Hampton Park, Littlehampton: Non-Material Amendment in relation to LEAP 1 on Parcel A2 pursuant to LU/305/19/RES

Please find enclosed the updated 'as built' plans for the Non-Material Amendment application in relation to the LEAP on Phase 3 at Hampton Park, Littlehampton.

The relevant approved drawing (A088461 LA303 Rev. S - Parcel A2 & B6 - LEAP Design) under reference LU/305/19/RES has been included in the submission for ease of reference. The above alterations are considered non-material, and fall within the scope of Section 96A of the Town and County Planning Act 1990.

## North Hampton Park LEAP: Parcel A2 & B6

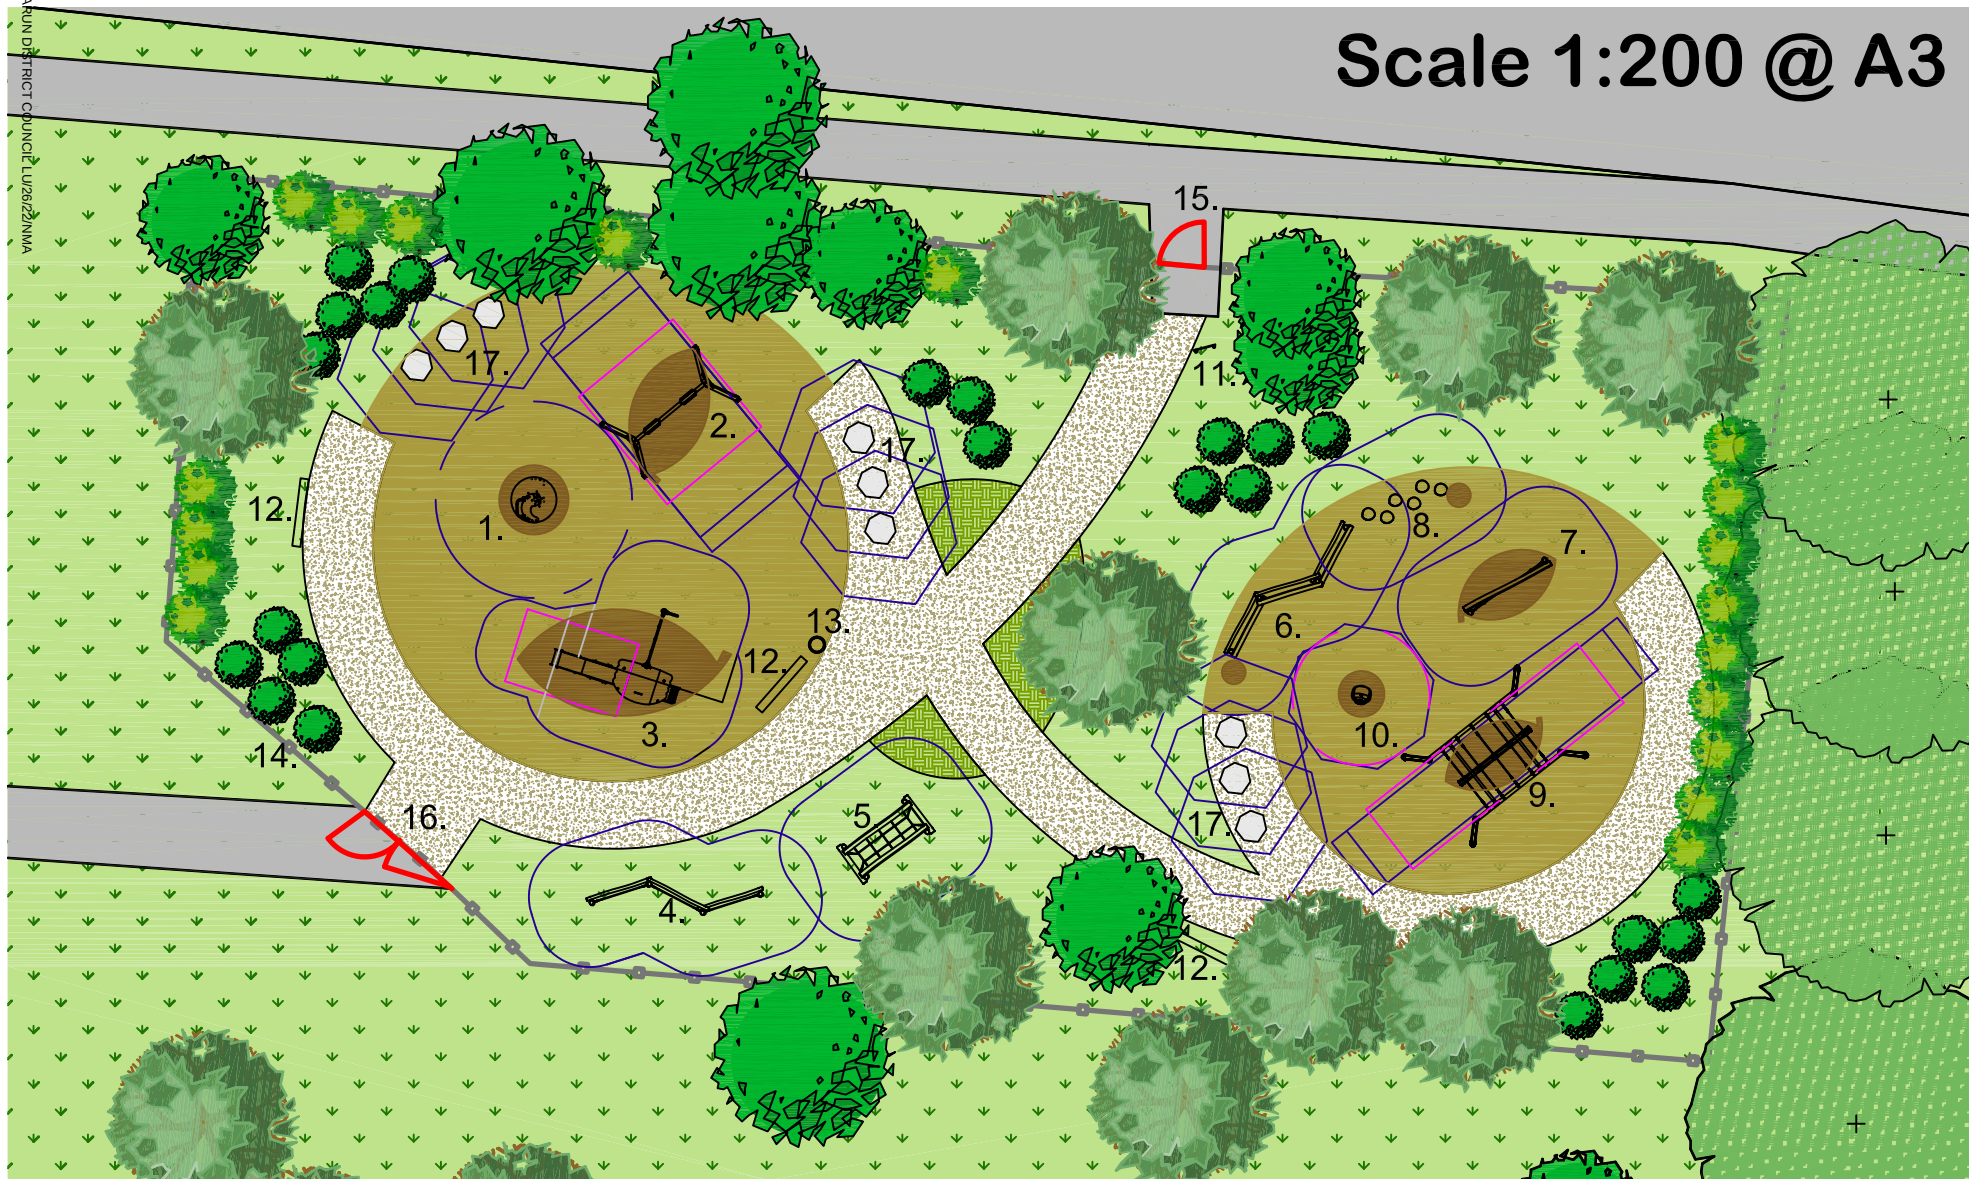
Item 6 – pendulum see-saw (item 9 on the as built drawings) has been replaced with a rope end swing that is the same play value, offers social swinging but actually allows for more children and users to play together. It is also constructed from stronger materials and durable components but is in keeping with the original design ethos.

Item 7 – revolving seat (item 10 on the as built drawings) has been replaced with a spinning seat which offers exactly the same play value but in comparison to the original plan, our seat is Inclusive, offers postural support and is made from stronger and durable materials.

Items 8, 9, 10 etc Trim Trail (6, 7, 8 on the as built drawings) have been provided with a direct like for like replacement incorporating climbing, balancing, traversing etc, meeting the same age ranges and materials.
